From: Amanda Scholes on behalf of Planning.Responses
Sent: 11 January 2019 08:52
To: Planning Scanning
Subject: FW: PL10 - S106 Deed Completion Statement - Land North of Water Lane Angmering - (A/40/18/OUT)
Attachments: RE: Land north of Water Lane, Angmering (A/40/18/OUT)

From: Michael Eastham
Sent: 07 January 2019 10:40
To: Joe Russell-Wells; Sue Howell; Sadie Tooley; 'CLAVELL-BATE, Simon (NHS COASTAL WEST SUSSEX CCG)'; [REDACTED]; 'Elaine Munns'; 'Stephen Gee'
Subject: PL10 - S106 Deed Completion Statement - Land North of Water Lane Angmering - (A/40/18/OUT)

The Landscape Strategy, Green Infrastructure and Landscape Mitigation Measures set out on pages 33 to 38 of the Design and Access Statement provide a good framework and starting point for the outline planning application (A/40/18/OUT).

1911 P 100 Location Plan
1911 P 101 Land Use Plan
1911 P 102 Building Heights Plan
1911 P 103 Illustrative Masterplan

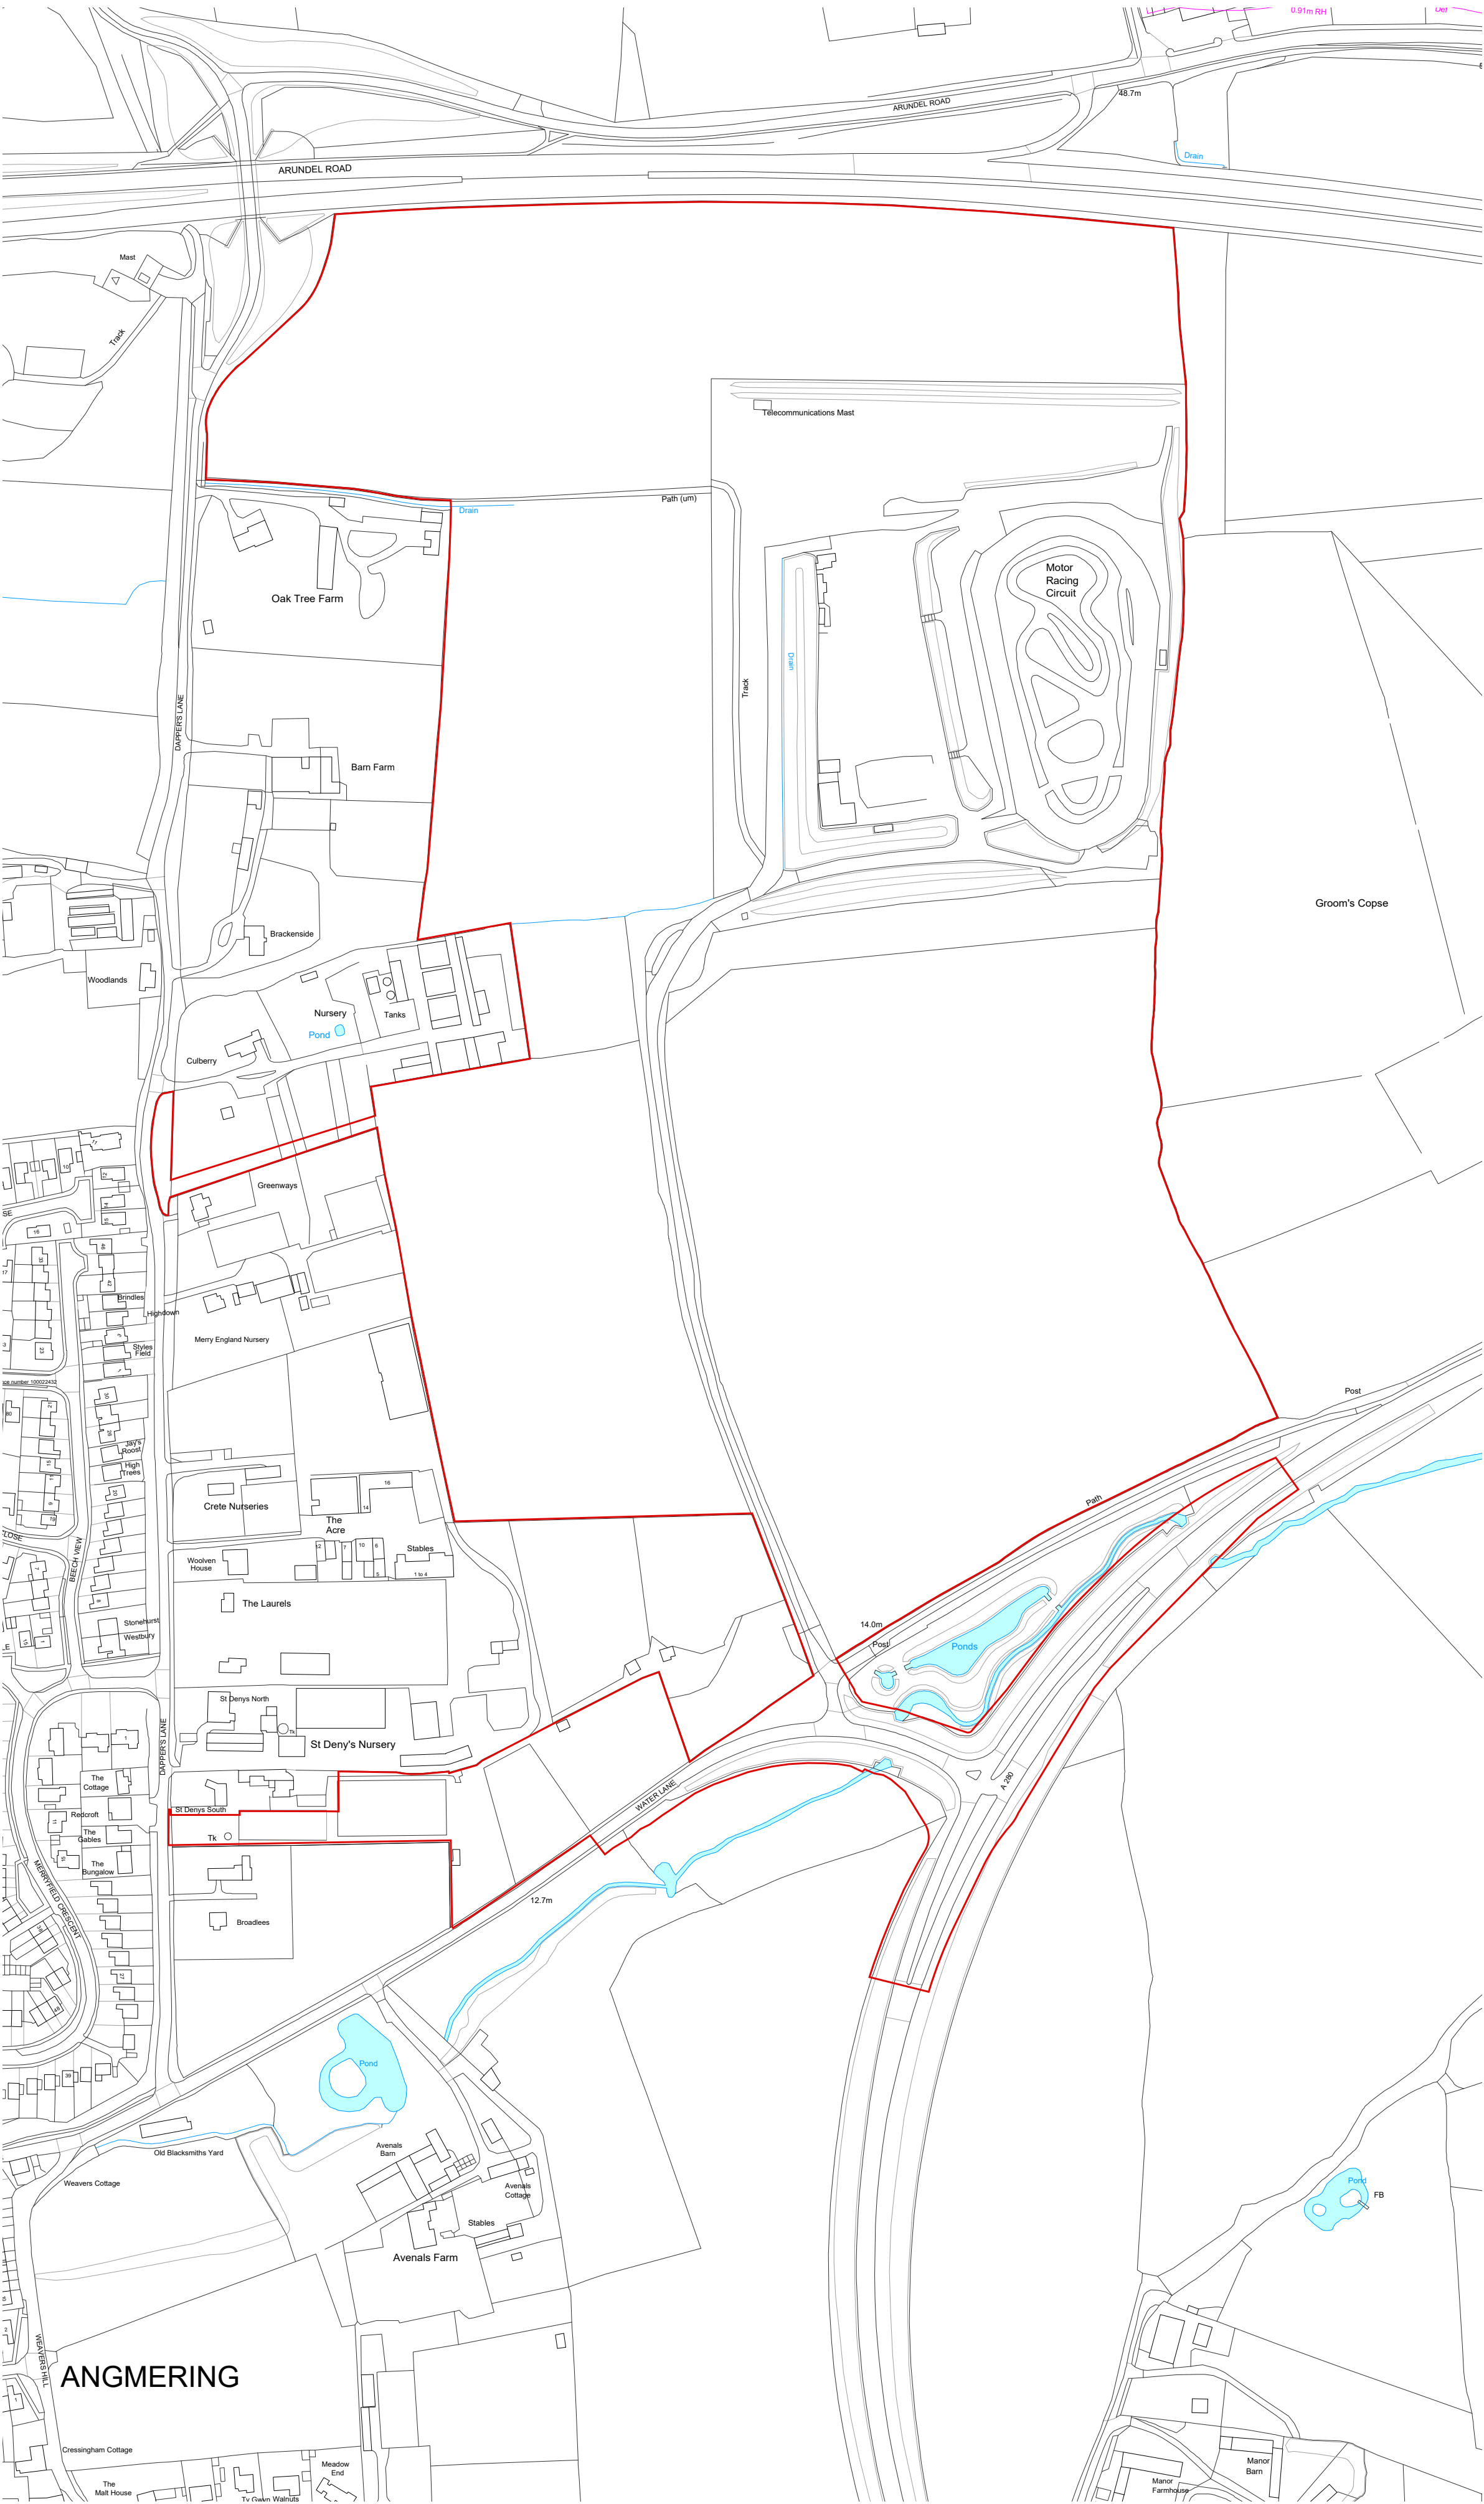
However, your Design Team will need to re-visit the Landscape Strategy Diagram on page 34 and the Green Infrastructure Diagram on page 36 to reconsider the location of the Kick-about / sports pitches in the northern part of the site. The kick about / sports pitches need to be centrally located and be closer to Angmering village for the local residents to use.

The linear park needs to be extended both in a north/south axis and an east / west axis within the application site.

There needs to be a pedestrian / cycle route in the north west corner of the site onto Dappers Lane and into the South Downs National Park.

The relationship of the proposed attenuation pond and the employment area at the southern part of the site needs to be re-considered, which may have a bearing on the landscape strategy.

The location of the proposed attenuation area in the ecological enhancement area at the centre of the site may need to be re-considered if you develop a central water feature running north / south through the site.

The 15 metre landscape buffer along the eastern boundary of the Ancient Woodland will need to be extended to the southern boundary of the site to mitigate the views into the site from the South Downs National Park.

As discussed just now we will remove the 'kickabout' area shown on the illustrative masterplan which is in line with the Council's approach at Palmer Road.

On the relationship of the proposed attenuation pond and the employment area we will review this on the drainage strategy and also any additional landscape work which is being provided.
